MH/CHS/2278

20 November 2024

2024/92553 Wappy Springs Inn, Lindley Moor Road, Lindley Moor, Huddersfield, HD3 3TD

With regards to the National Highways response, I refer to the 5 bullet points under Temporary Non-Approval below:

TITLE
DRAINAGE LAYOUT

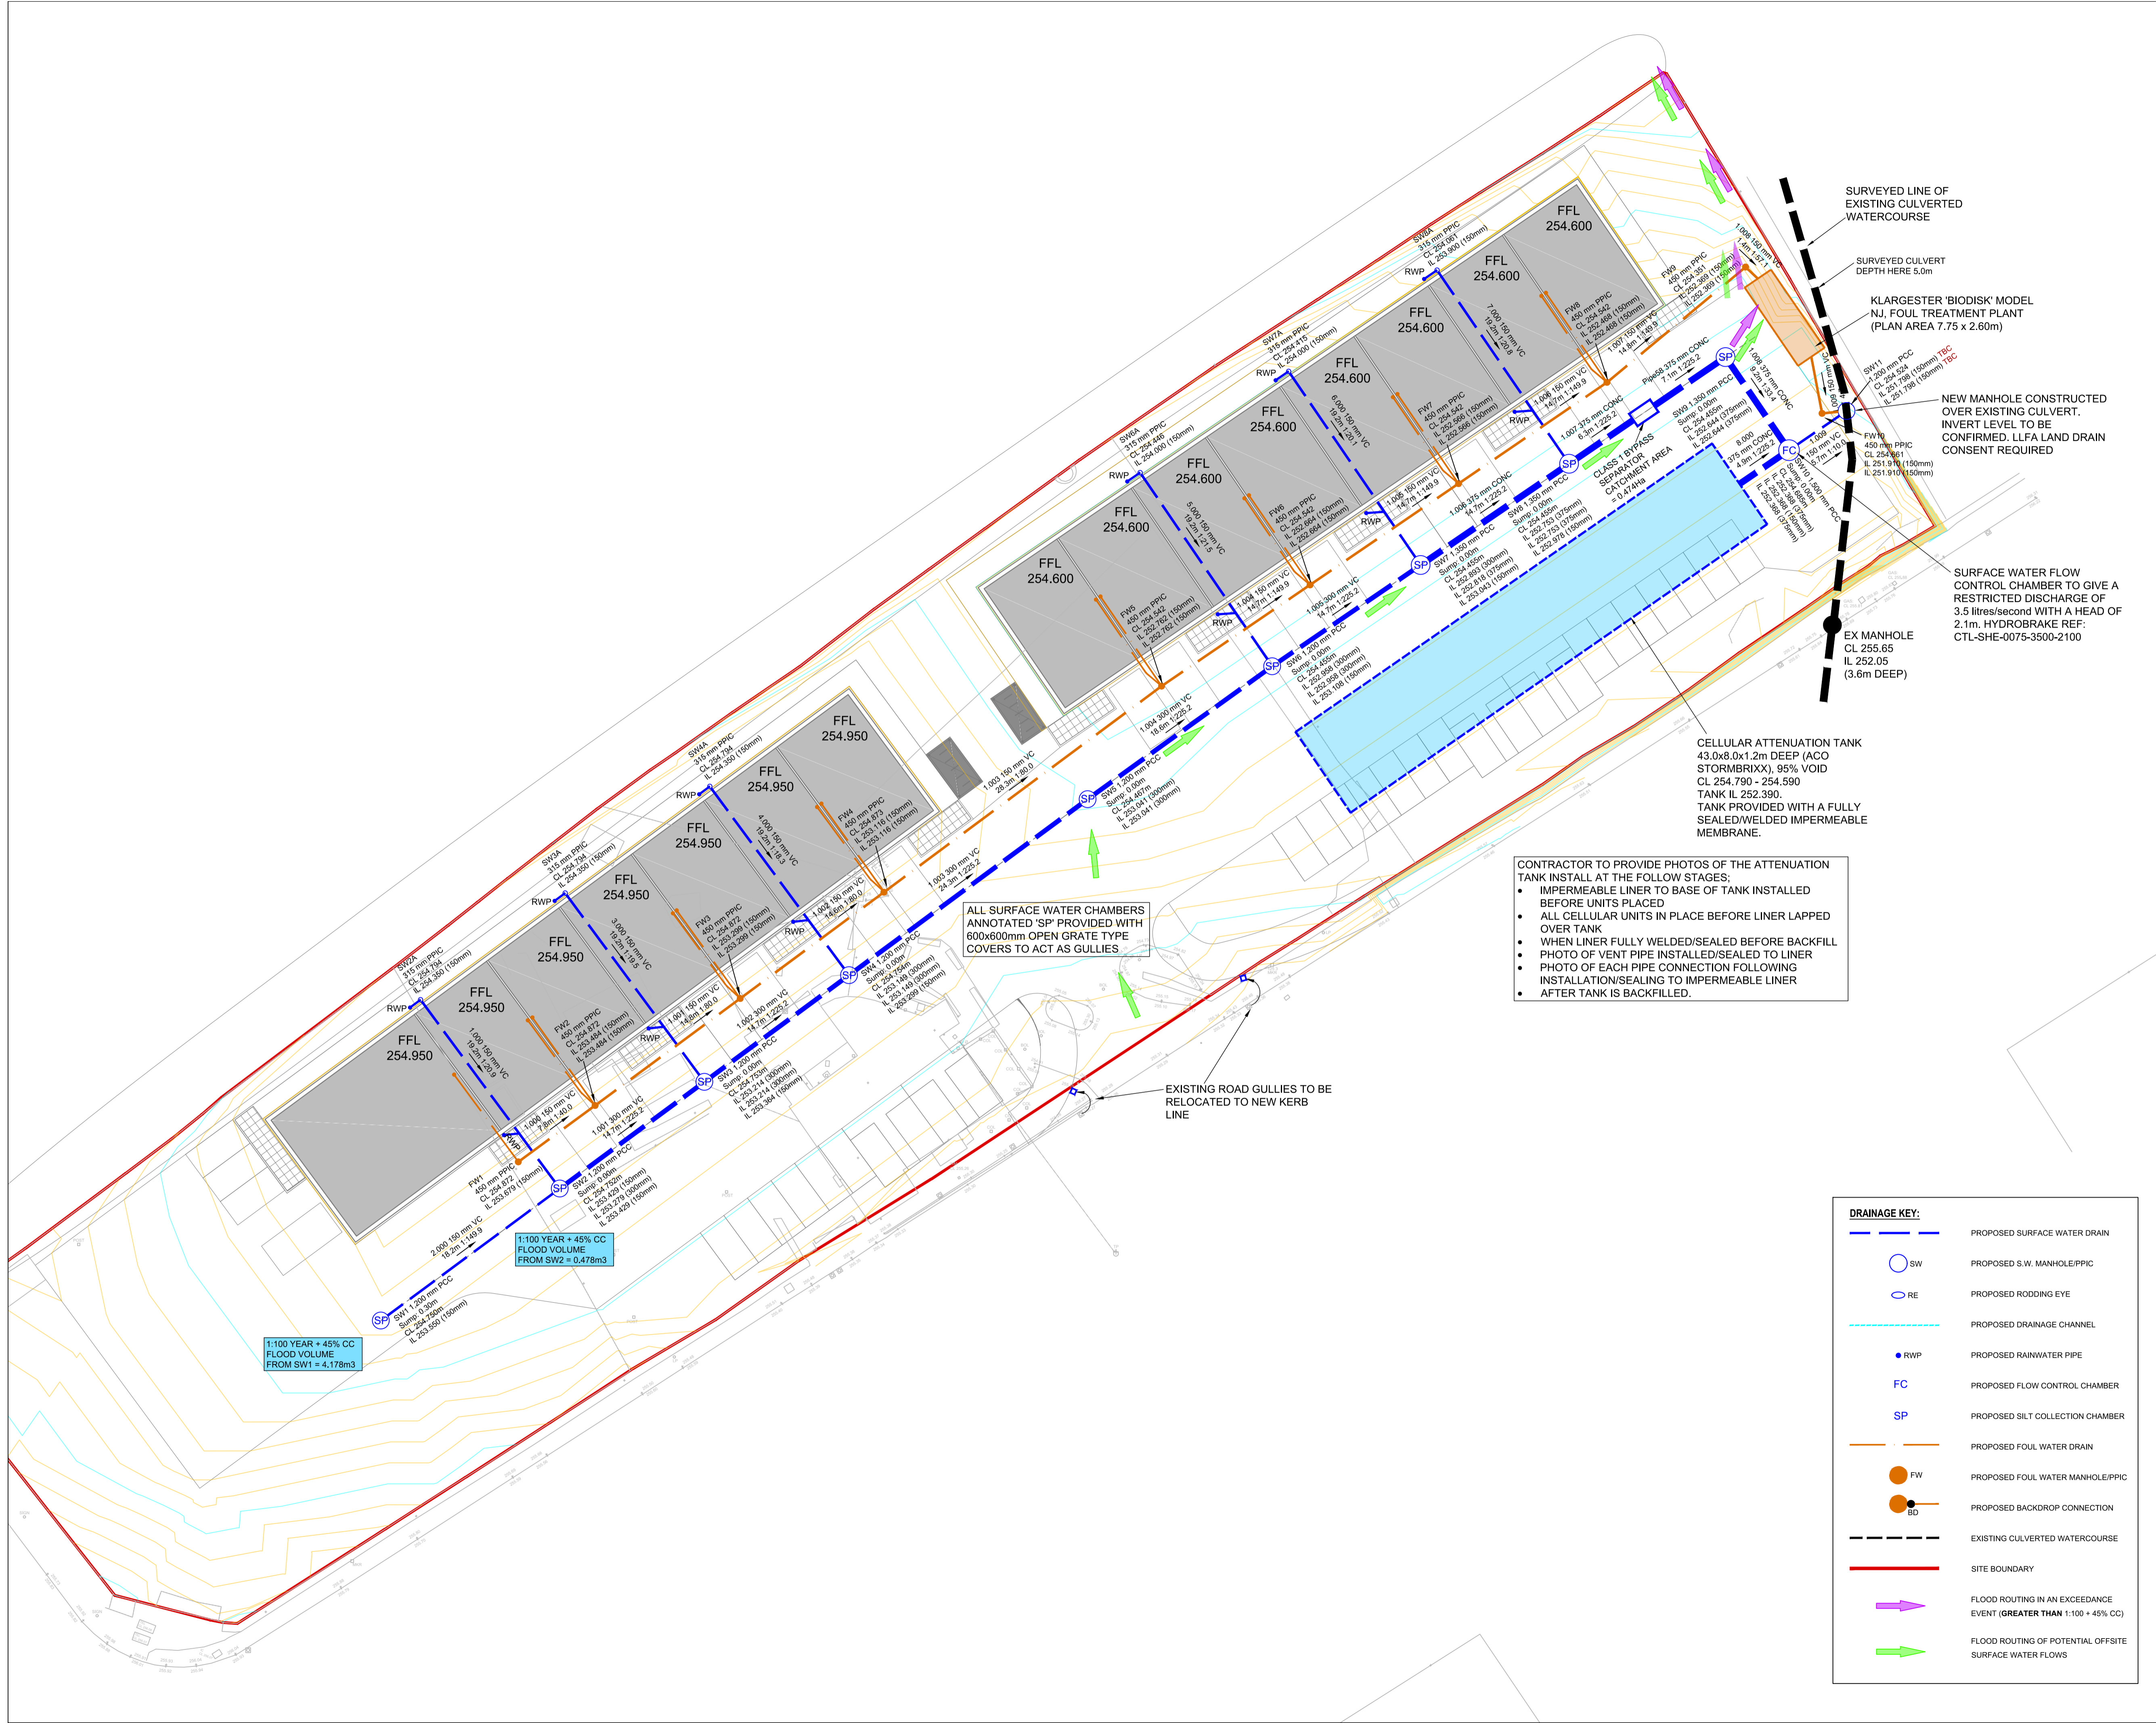
- The foul treatment plant will be maintained in accordance with the manufacturer's recommendations. Please see the attached installation guide and in particular Section 9 which goes over the maintenance details.

PALADIN FENCE (COLOUR BLACK)
 SCALE 1:50
 (REFER TO PLAN ABOVE FOR LOCATION)

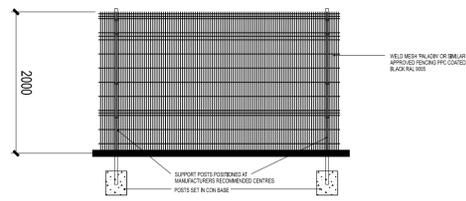
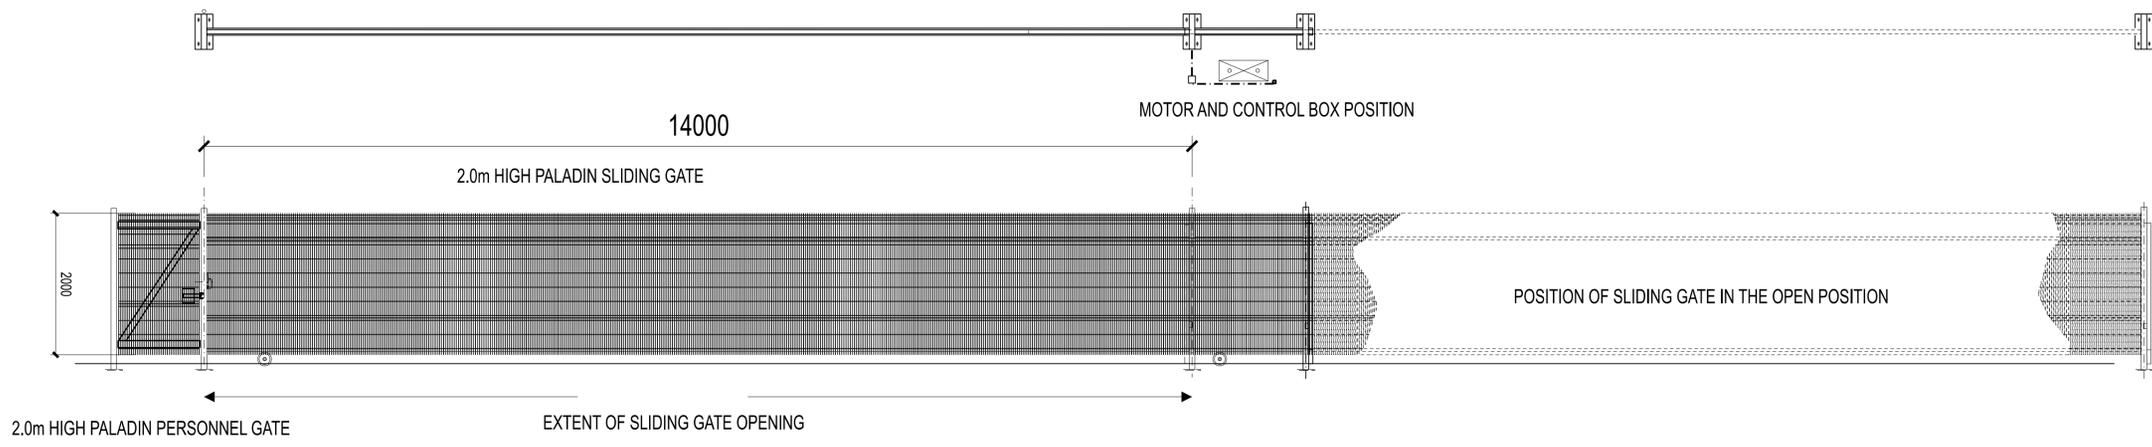
- With reference to the level changes along the rear boundary; the proposed fence line is to follow the existing fence line / site boundary and is therefore within our client's ownership. The existing fence should set a precedent for boundary protection. I have had confirmation from the client that they would be happy to provide a timber fence as opposed to a paladin fence to the rear if this would be more agreeable. To my knowledge we are not proposing any level changes within close proximity of the boundary, the retaining wall as shown to the rear of units 1-4 is a deadwall incorporated into the line of the masonry to the rear of the building, which is over 3m from the site boundary and therefore should have no impact on the stability of the embankment.

- We cannot find any record of exact legal agreement with regards to access onto the site, however we appreciate that should maintenance access be required there needs to be adequate space to the rear of the buildings. Per my previous bullet point we would agree to change the fence from paladin to timber if this would be beneficial from a maintenance access perspective. Please advise.
